**Wetherill Park Resource Recovery Facility (SSD-7401-Mod-1)
Planning Secretary's Environmental Assessment Requirements**

**Attachment 1: Planning Secretary's Environmental Assessment Requirements
Wetherill Park Resource Recovery Facility (SSD-7401-Mod-1)**

SEARS REQUEST FOR ADVICE (SSD-7401-MOD-1) – Proposed increased processing capacity, additional wastes streams and new shredding

PROJECT	PROPOSED GREENSPOT RESOURCE RECOVERY AND RECYCLING FACILITY 24 DAVIS ROAD WETHERILL PARK NSW 2164	PROJECT NO.	1521
CLIENT	BETTERGROW	SCALE	1:200
TITLE	MUD PROCESS AREA PROPOSED SITE PLAN	JOB NO.	0604-16
		SHEET NO.	A03
		ISSUE	B

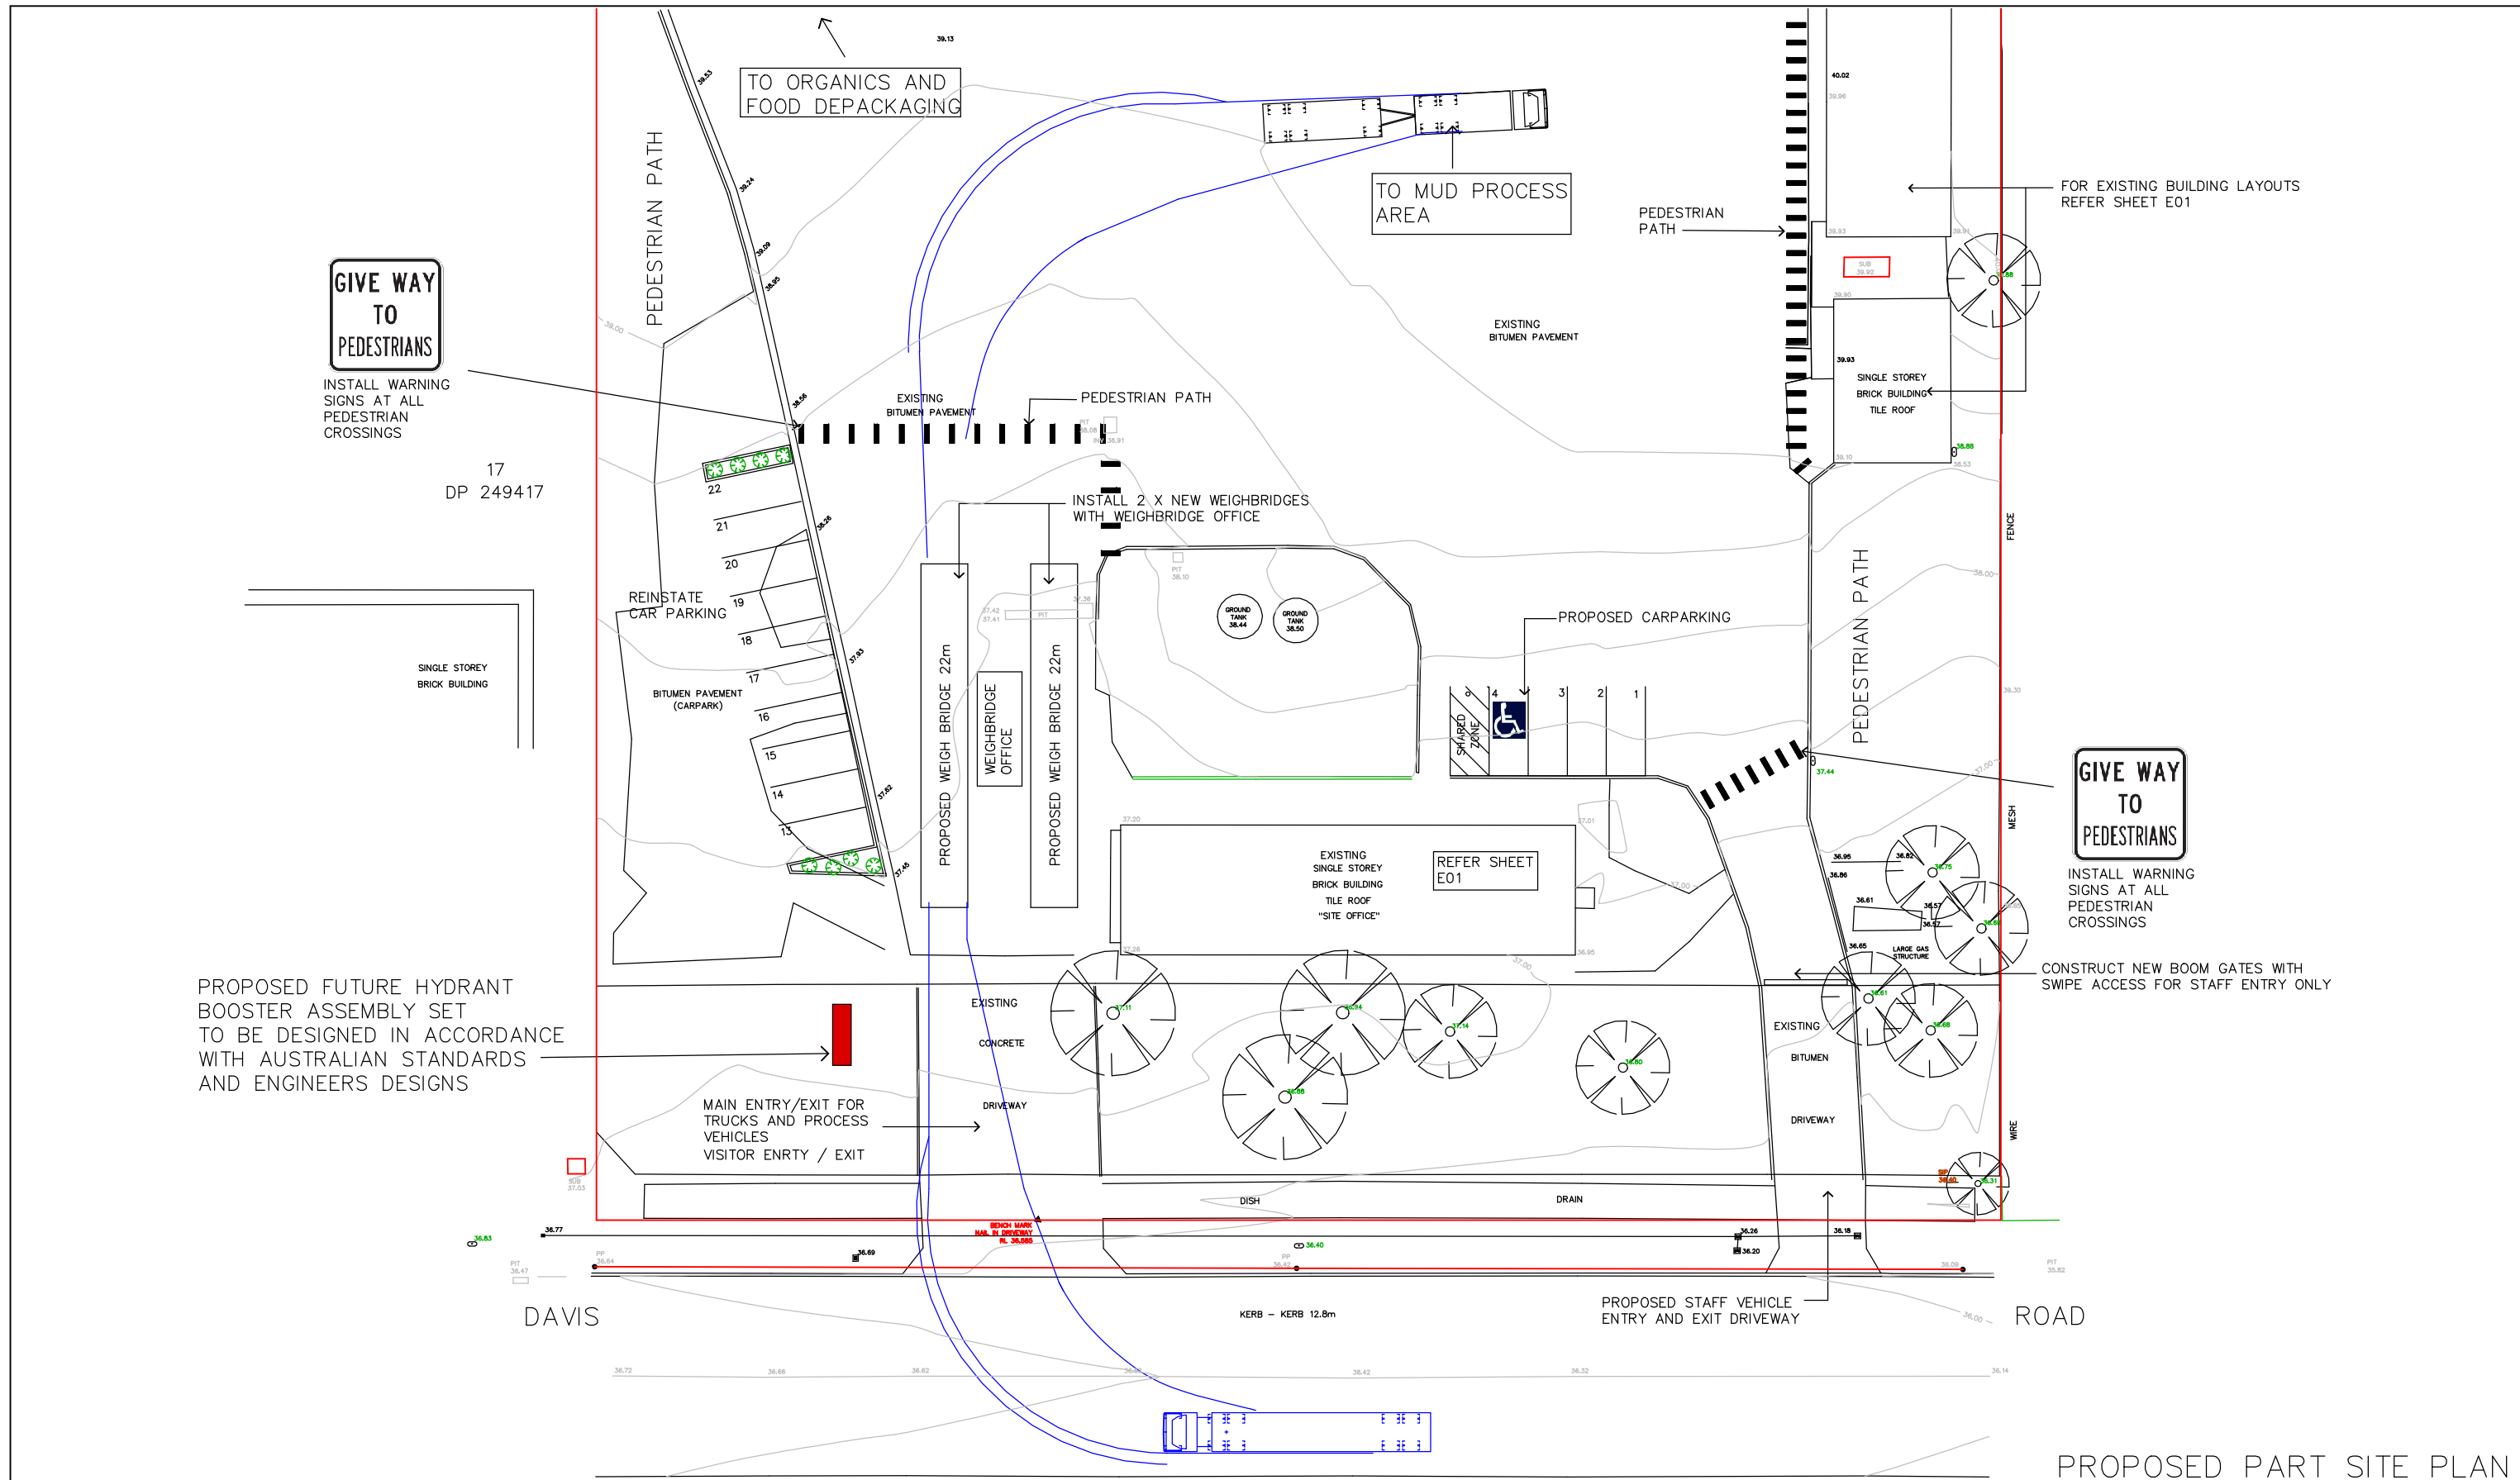
- The applicant's turning path diagram (Job No. 0604-16 Sheet No. A03) shows heavy vehicles manoeuvring within the site are impacted by trucks parking within the site and the concrete slab structure for mud processing area. Additional information shall be provided to address this concern.

- The applicant's swept path diagram shall demonstrate how two-way traffic movements will be accommodated at/near the entry/exit driveway. This information shall be provided to Council for assessment. The width of the driveway shall be designed to accommodate the simultaneous movements of a 19m B-Double vehicle and another vehicle and this shall be justified by turning path analysis.
